**REQUEST**

Current Zoning: I-1(CD) (light industrial, conditional) and R-22MF (multifamily residential)  
Proposed Zoning: I-1(CD) (light industrial, conditional) and I-1(CD) SPA (light industrial, conditional, site plan amendment)

Approximately 9.54 acres located north of Perimeter Pointe Parkway, west of Rebecca Avenue, and south of West Boulevard.

**SUMMARY OF PETITION**

Childress - Klein
Development Standards
Rezonning Petition No. 2020-094

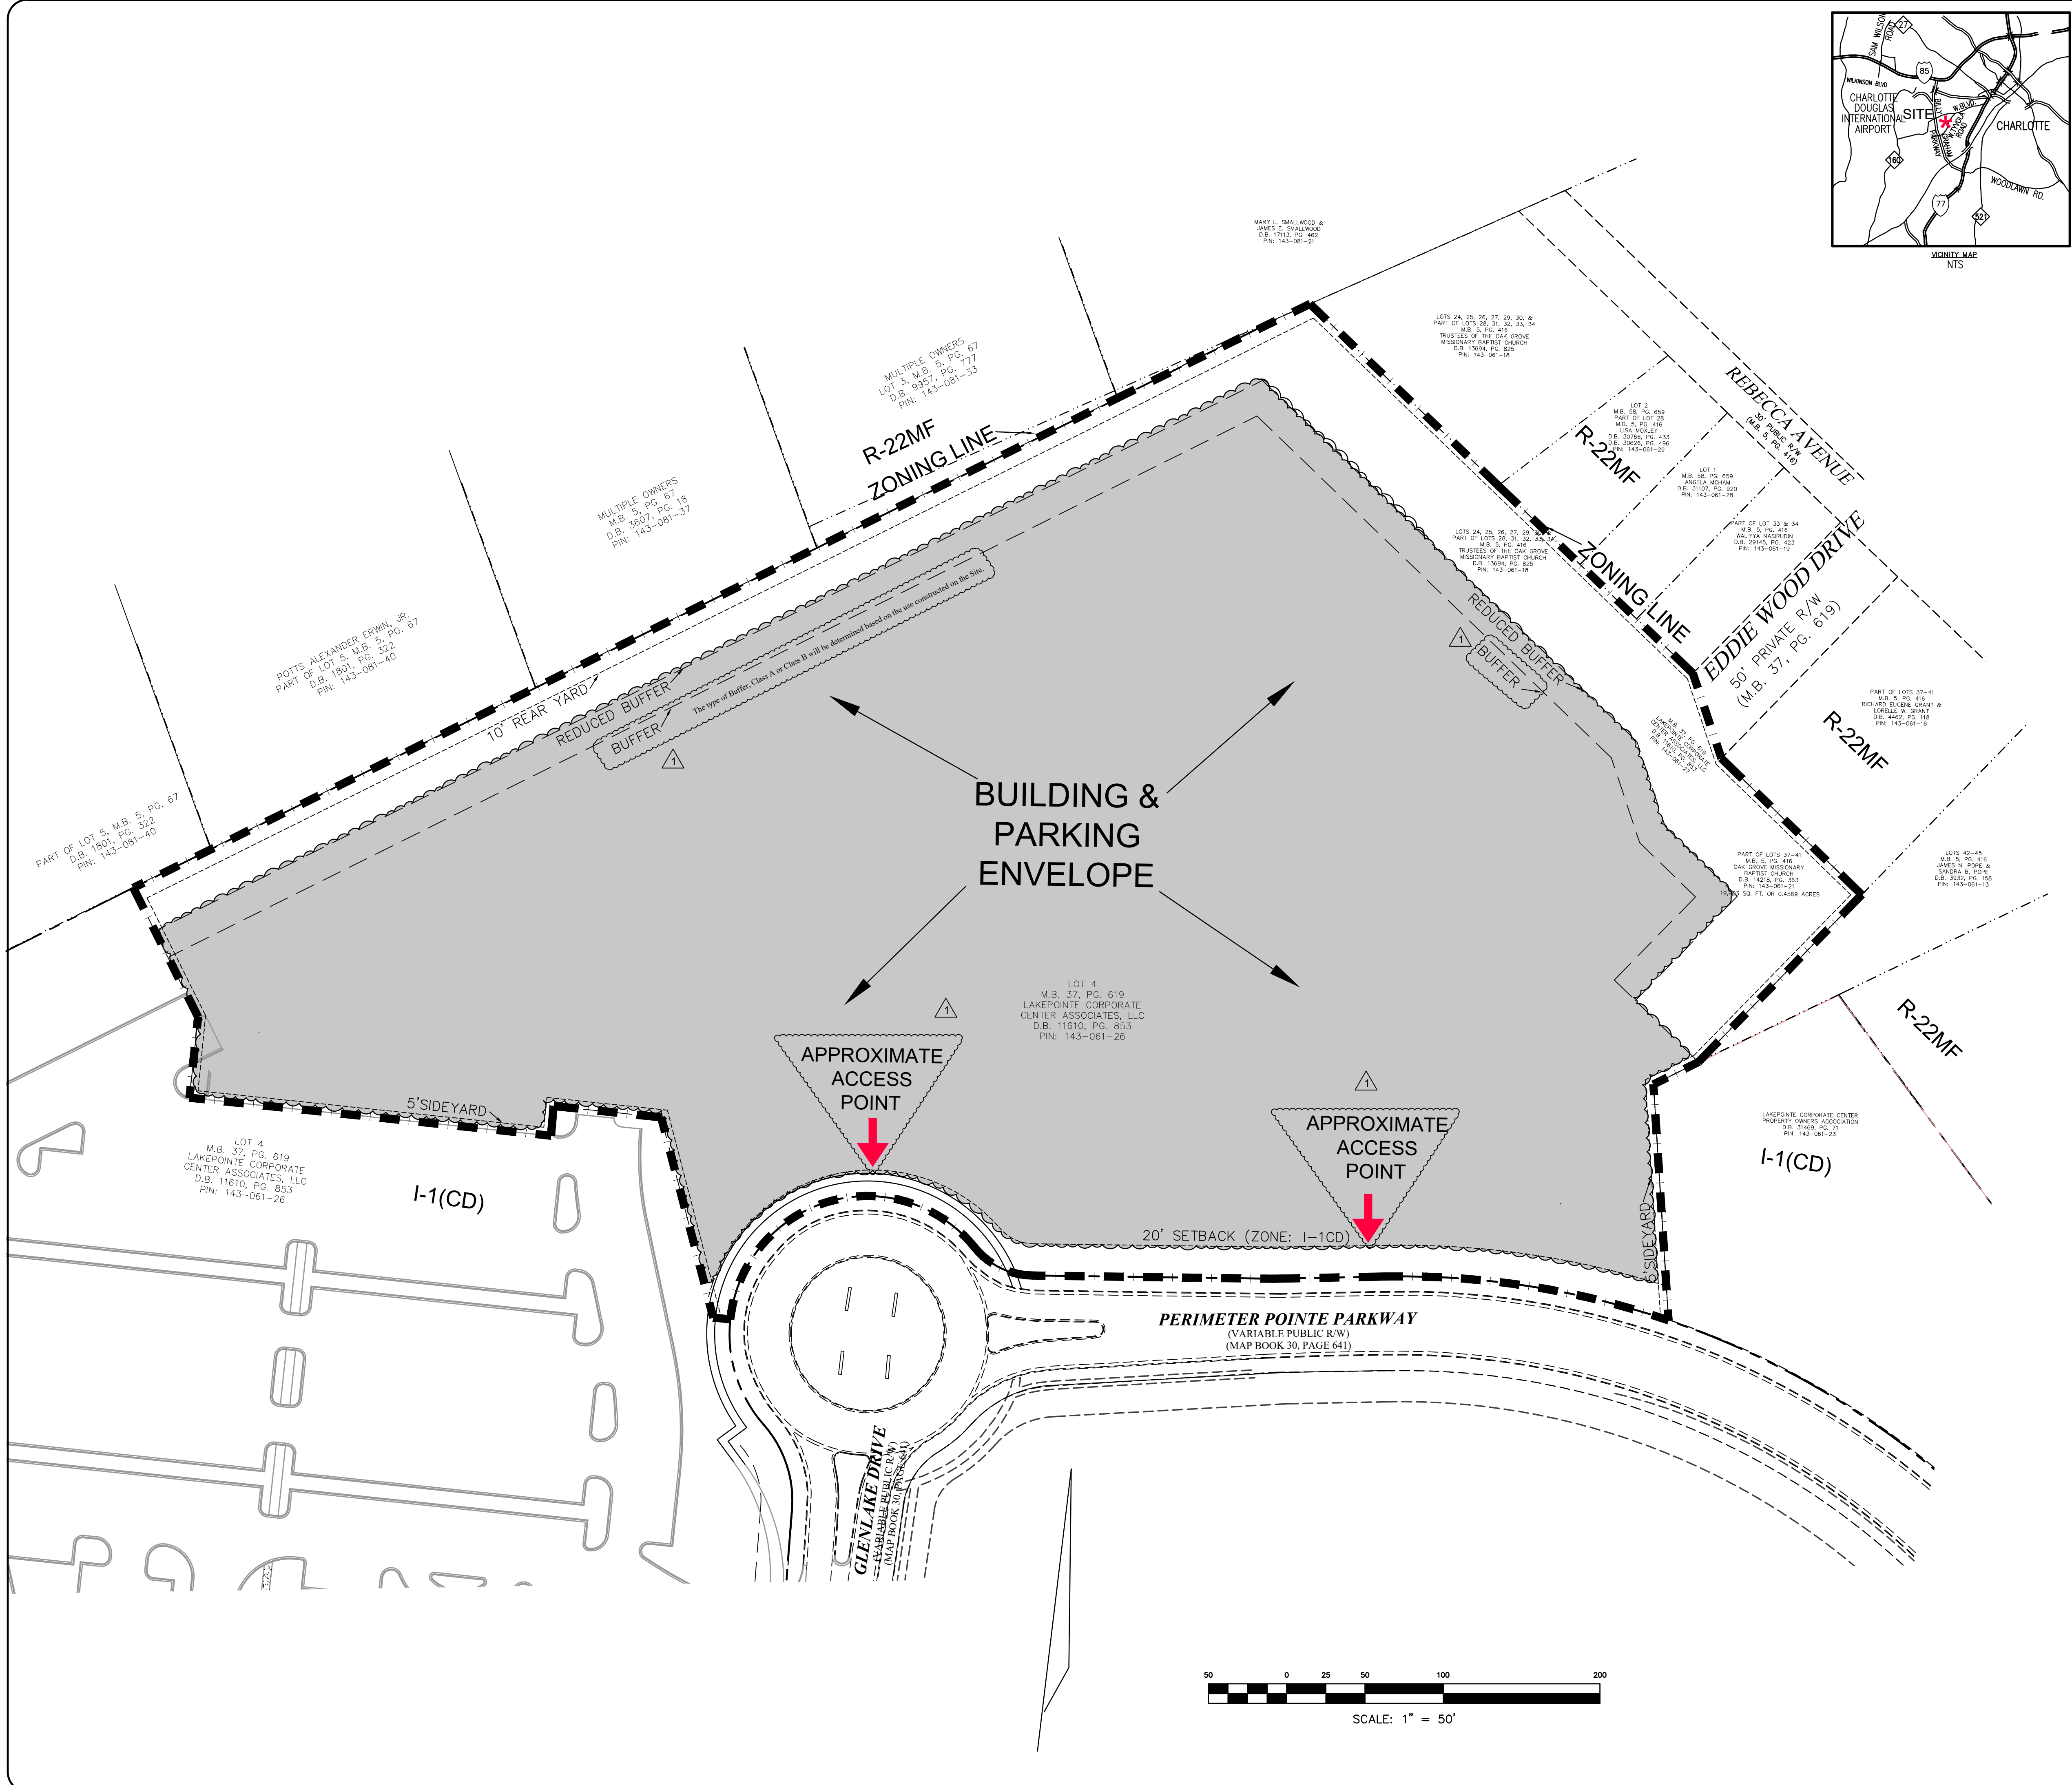
1. Revise the site plan and conditional note(s) to commit to construct an 8-ft planting strip, and 6-ft sidewalk on Perimeter Pointe Parkway as per Charlotte WALKS. This sidewalk need to tie into the existing network at the adjacent parcel, 14306125, and extend to the curb ramp at Tyvola Road. Label and dimension both items from the back of curb and gutter and road centerline.

2. Revise the site plan and conditional note(s) to clarify access point(s). The petitioner should have at least one access point that stems off the roundabout, creating the third leg. Turning movements should be performed to ensure the roundabout may function for the petitioner's design vehicles.

3. Add a conditional note to clarify these turning movements will be shown during the permitting process.
4. Revise the site plan to add a note specifying all transportation improvements will be approved and constructed before the site's first building certificate of occupancy is issued. The petitioner may phase transportation improvements if said improvements and phasing are explicitly described in site plan notes.
